12 November 2013

Aldwick Farm, Aldwick Rd, Bognor Regis
Condition 3 – Revised matters regarding ref. AW/74/13... and AW/75/13/L

R.872 **11**
A

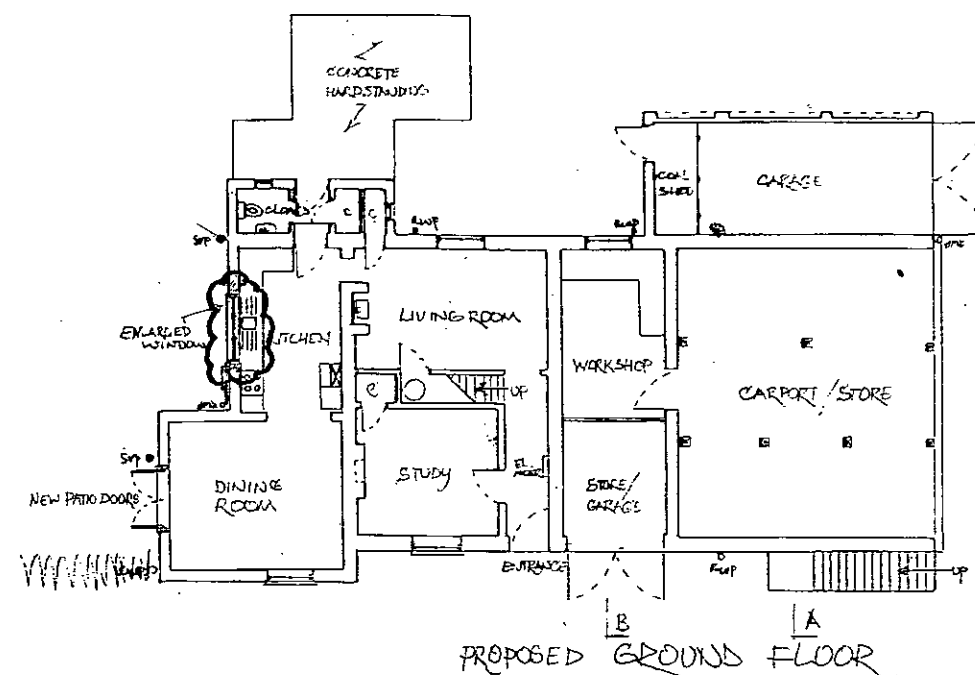
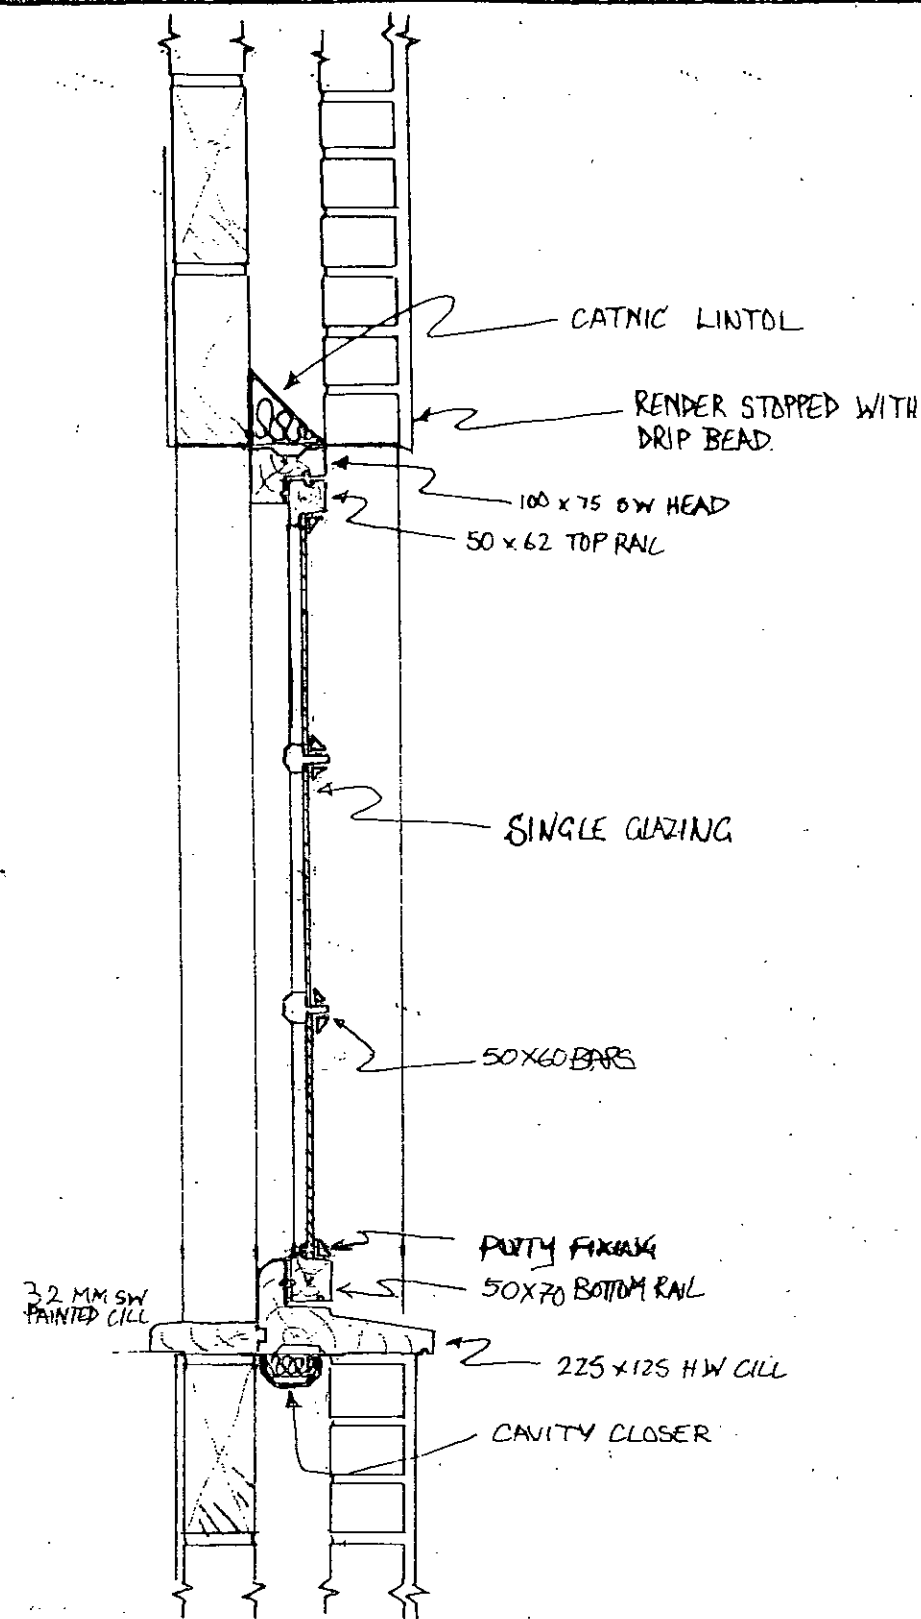
We have amended the drawing R.872 to exclude the double glazing and resubmit the enclosed discharge of condition forms for both the planning and Listed building consents.
